Heckington Fen Solar Park

EN010123

Cover Letter

Change Notification (our document reference – PreExA.CL.CN.v1)

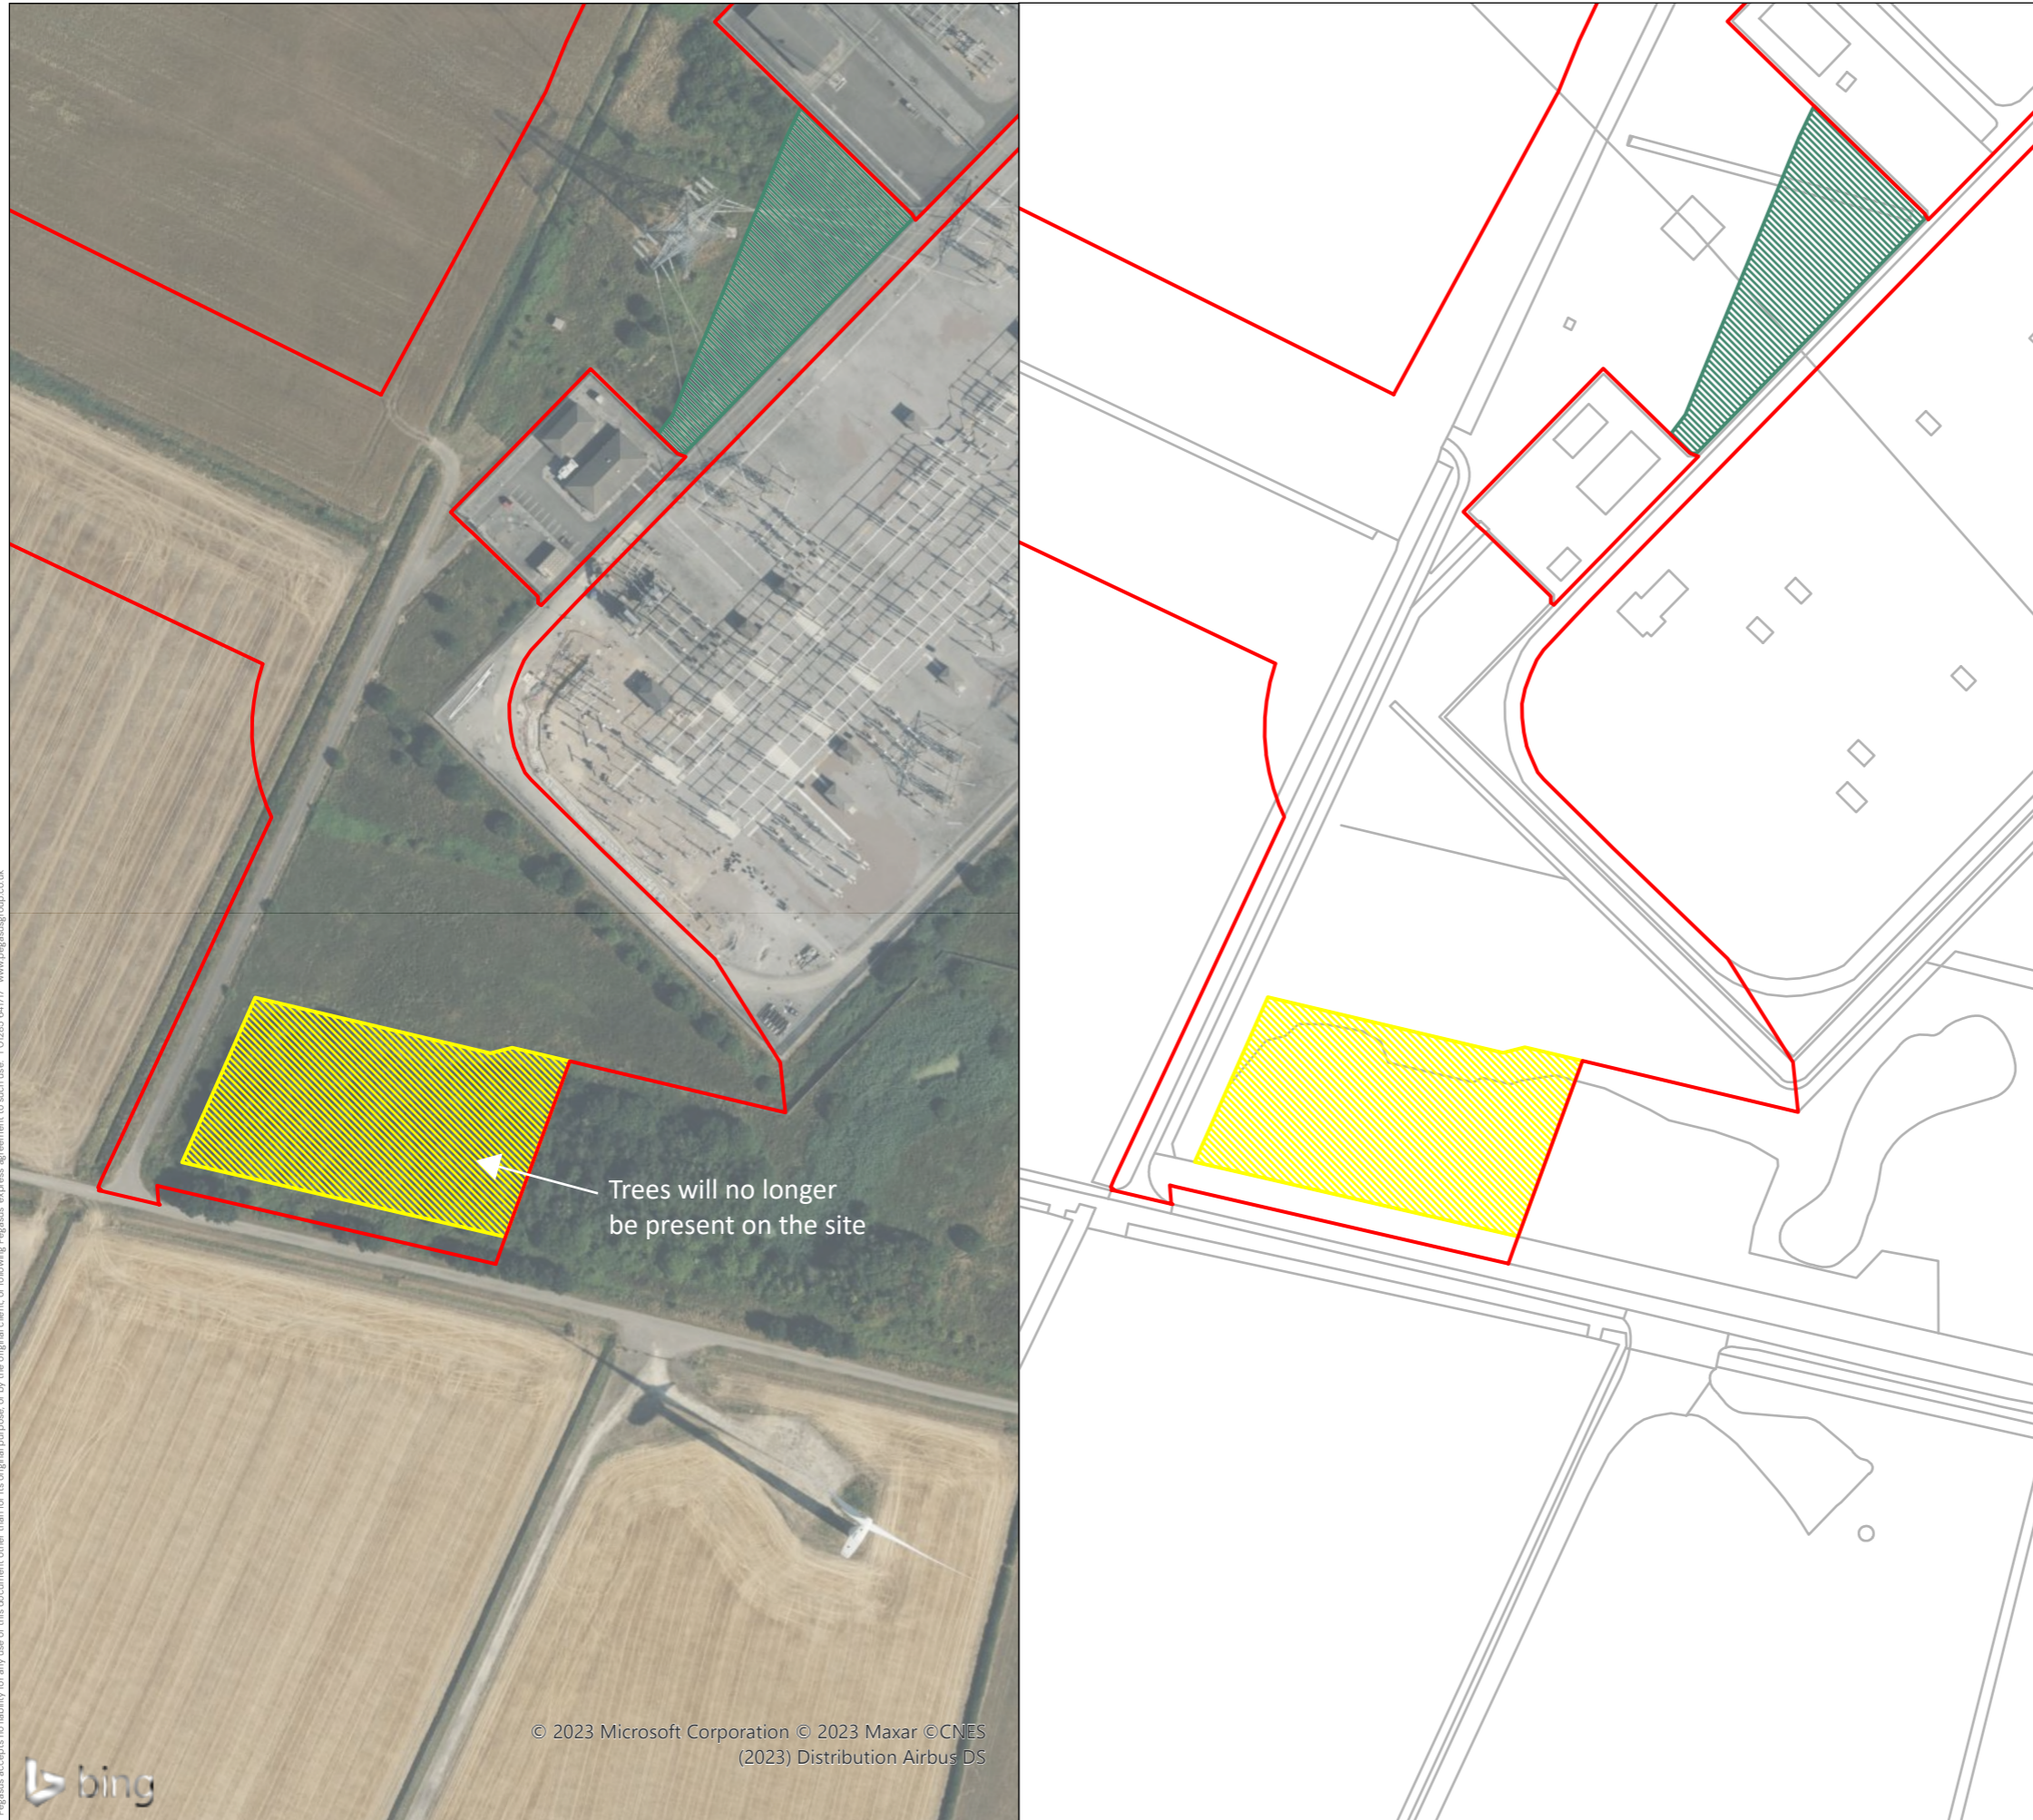
1. a new section of NGET infrastructure at the substation comprising a busbar extension including a section breaker, a bus coupler and a feeder circuit on land to the south of Bicker Fen Substation, which is owned by NGET; and
2. a new cable sealing end ("CSE") compound on land to the west of Bicker Fen Substation which is owned by NGET.

Accordingly, a larger area is needed to facilitate the Applicant's connection into the Bicker Fen Substation. The full extent of the land area covered by the change is shown in yellow and green shading on Figure 1 appended to this letter.

- Proposed Order Limits
- AW1
- AW2
- Submitted DCO Order Limits

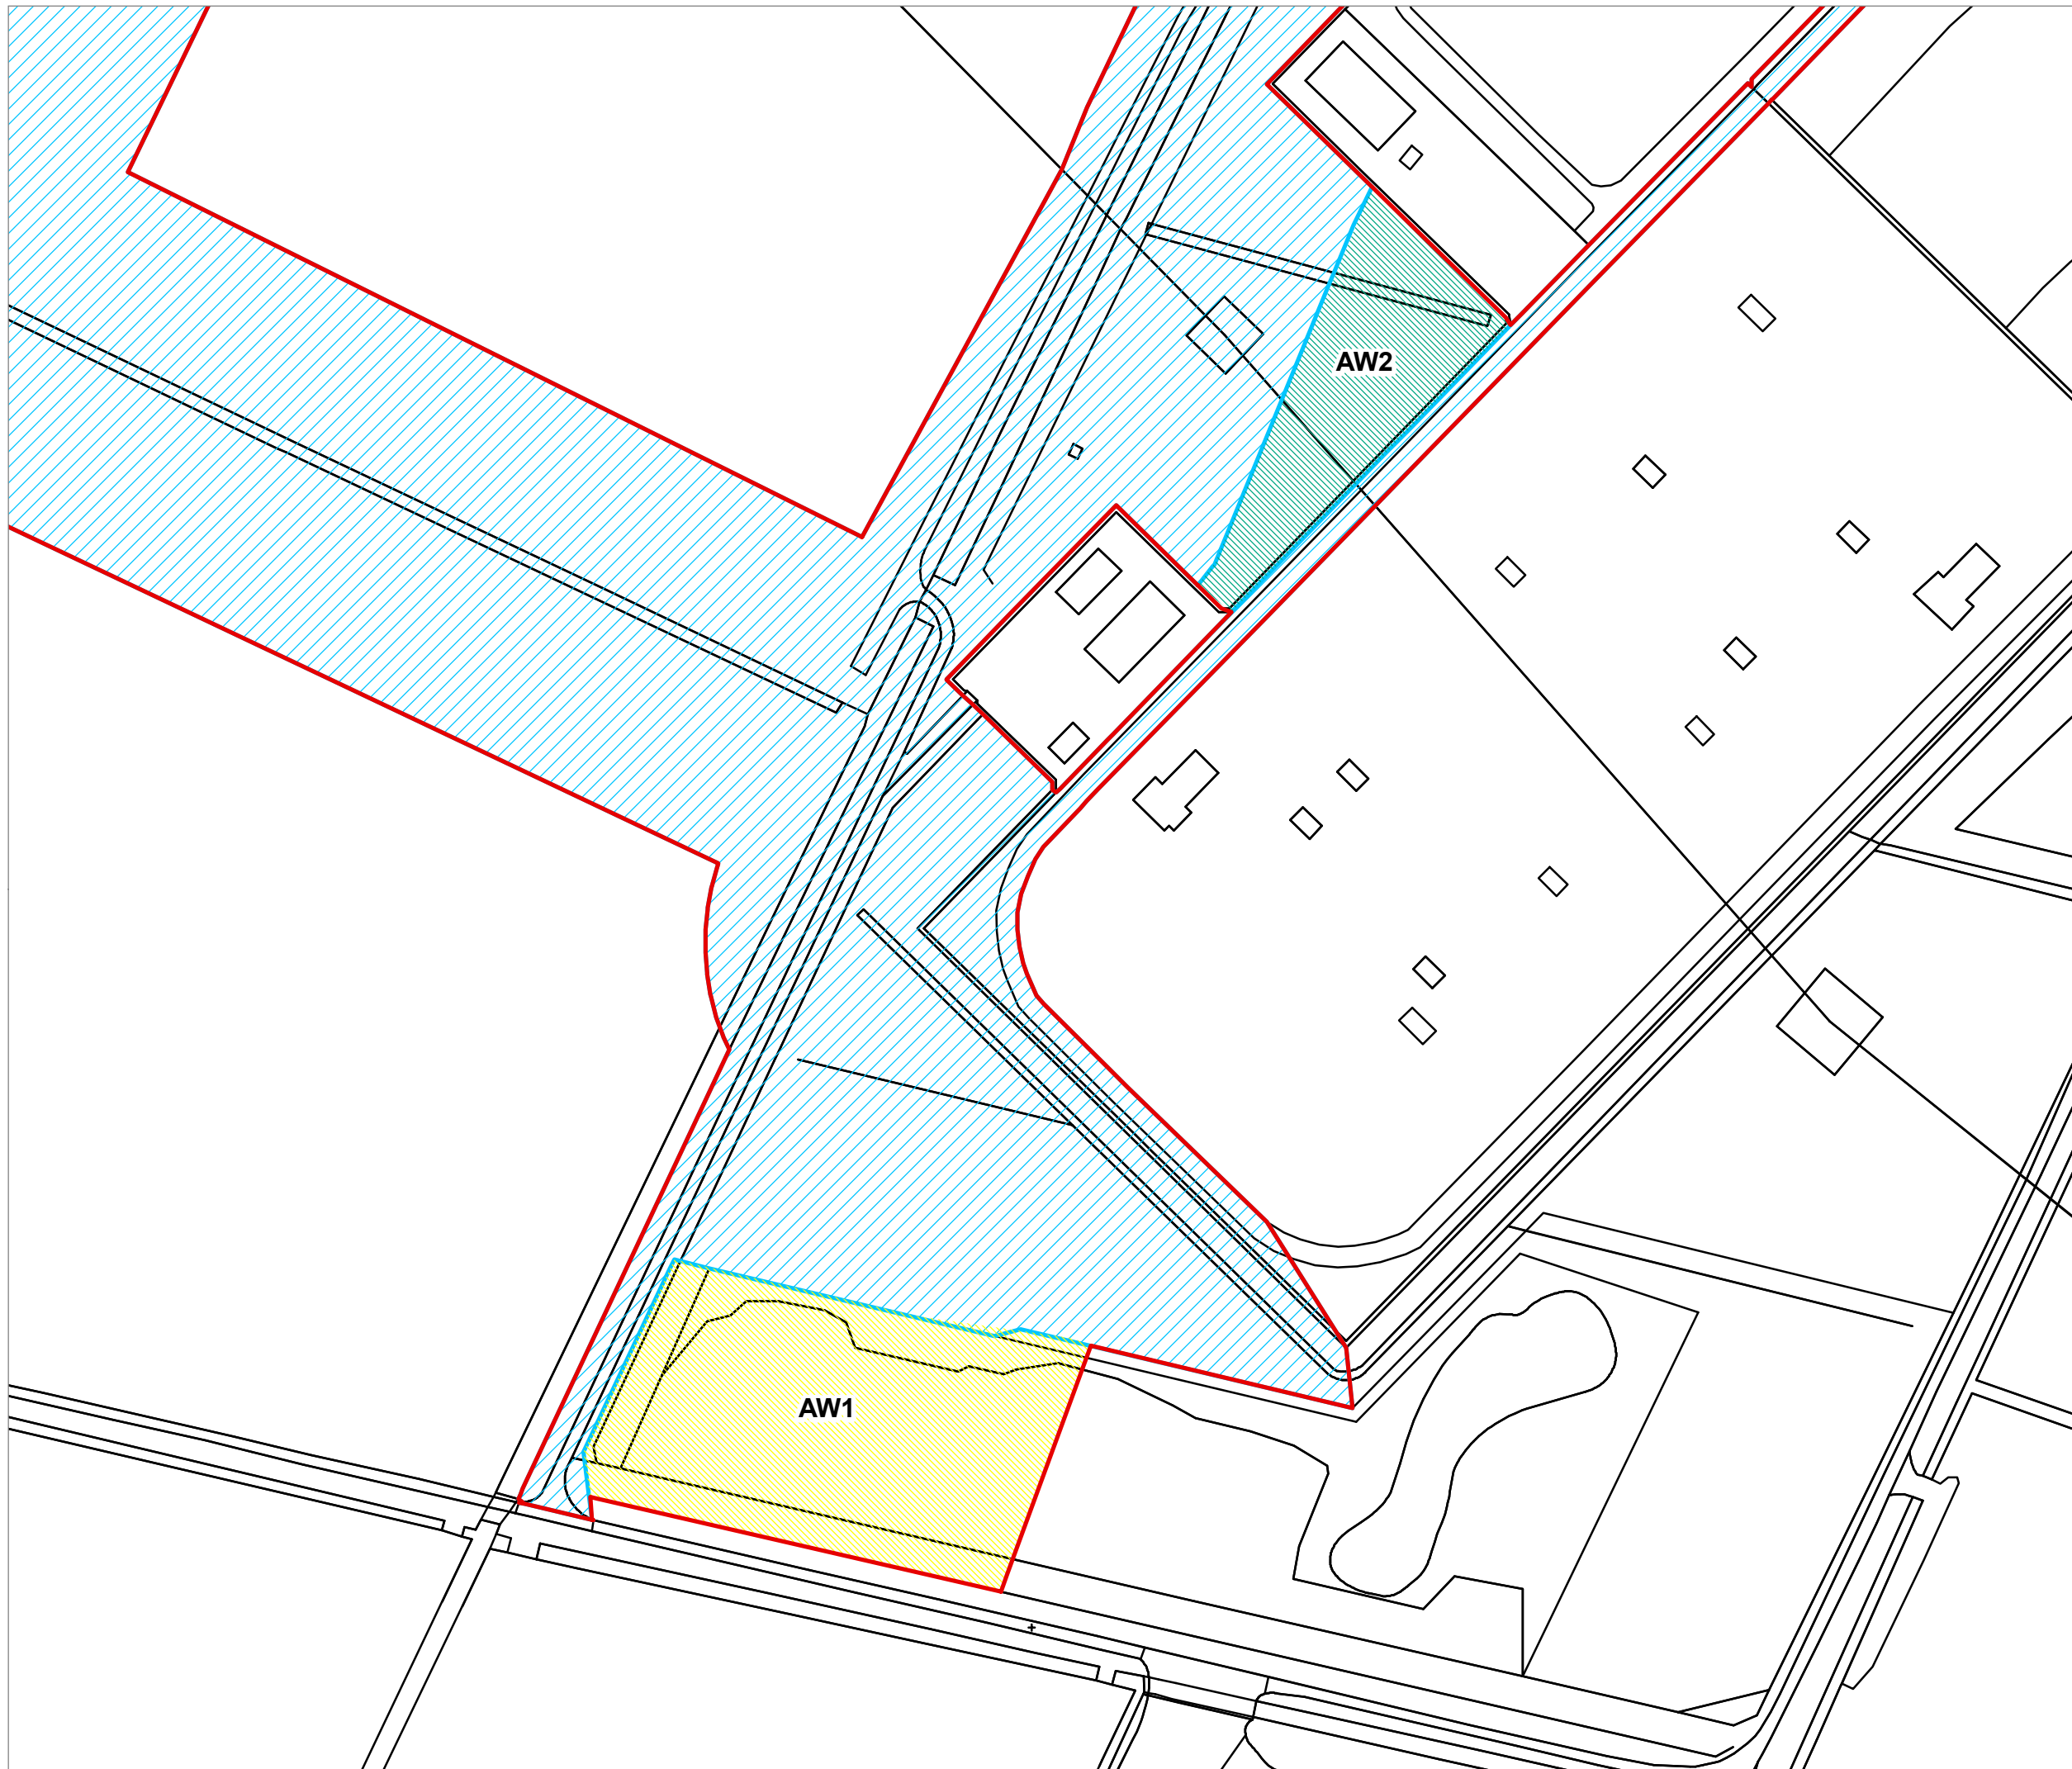
1. a new section of NGET infrastructure at the substation comprising a busbar extension including a section breaker, a bus coupler and a feeder circuit on land to the south of Bicker Fen Substation, which is owned by NGET ("AW1"); and
2. a new cable sealing end ("CSE") compound on land to the west of Bicker Fen Substation which is owned by NGET ("AW2").

The change will require approximately 0.9ha of additional land at the Bicker Fen Substation. The land is under National Grid's ownership. At this stage it is the Applicant's intention to include rights of compulsory acquisition over the additional land. The Applicant is in discussions with National Grid and expects to be in a position to provide a consent letter with the Change Application confirming that the additional land can be included in the application for compulsory acquisition.
